Recommendation Report for Planning Permission

REF NO: P/95/21/PL

LOCATION: Bowley Farm
Bowley Lane
South Mundham
Chichester
PO21 1NB

PROPOSAL: Retention of 4 mobile homes for countryside workers together with drainage and service connection provision in connection with permission P/72/09 as varied by P/22/017/PL (resubmission following P/86/20/PL). This site is in CIL Zone 5 (Zero Rated) as other development.

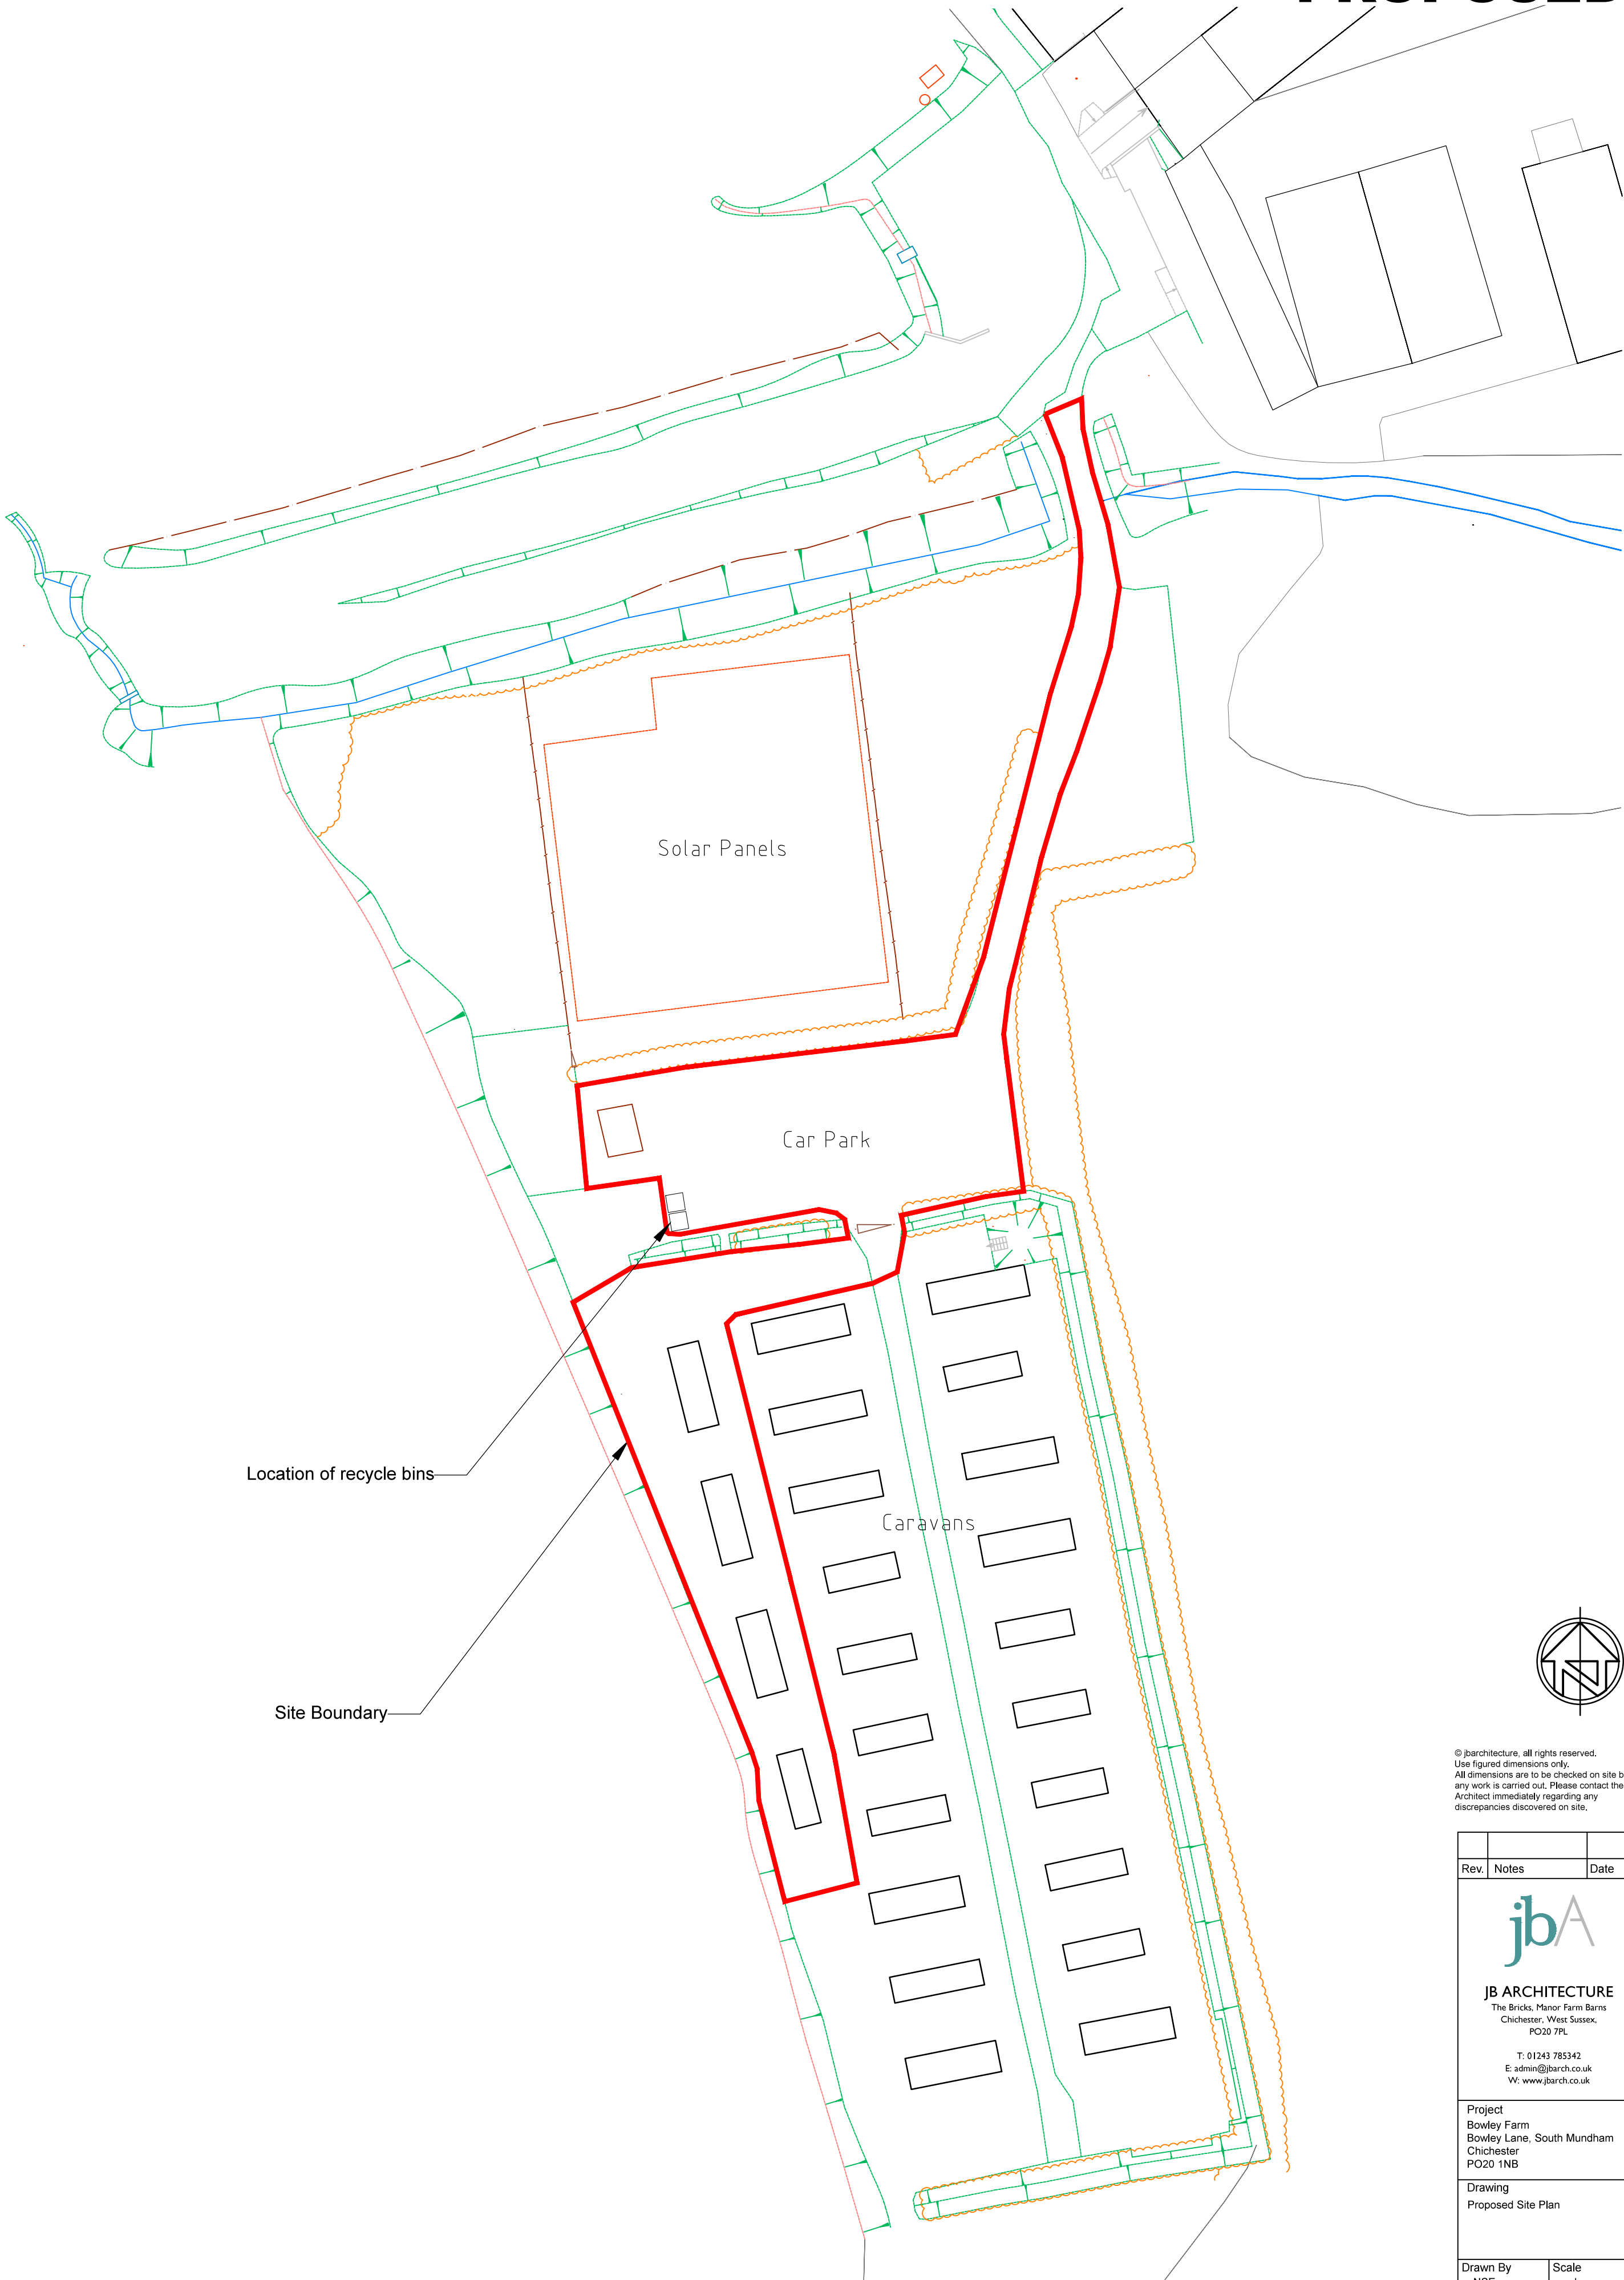
The proposed mobile homes, are in the buffer zone alongside the watercourse (min 5m wide measured from bank top for the whole extent of the site) which should be without structures, footpaths and should not include formal landscaping. This was the requirement of the Environment Agency in line with s.23 of the Land Drainage Act 1991 and s.109 of the Water Resources Act 1991 to protect the adjacent watercourse and land alongside watercourse with its wildlife. As mentioned in the advisory information of the Environmental Agency (P/86/20/PL), water voles have been previously recorded in close proximity to existing ditch network. The Ecology Officer stated in her comments: 'Due to the presence of water vole habitat, no works can take place within this ditch or area and a 5m buffer should be set up from the ditch bank to ensure this area remains undisturbed.'

Since these 4 mobile homes occupy the same position assessed under P/86/20/PL, in the defined buffer zone, therefore still represents the potential threat to groundwater pollution and disruption or loss of the protected species. Contrary to the Arun Local Plan policies W DM1, ENV DM5 and H DM3 and paragraph 175(a) of the National Planning Policy Framework.

- 1 The mobile homes are in a buffer zone (approved by P/72/09) alongside the watercourse which should be kept without structures, footpaths and formal landscaping to protect the watercourse and the wildlife. The proposal represents a threat to groundwater pollution and disruption or loss of the protected species, in conflict with policies ENV DM5 and W DM1 of the Arun Local Plan and paragraph 175(a) of the National Planning Policy Framework.
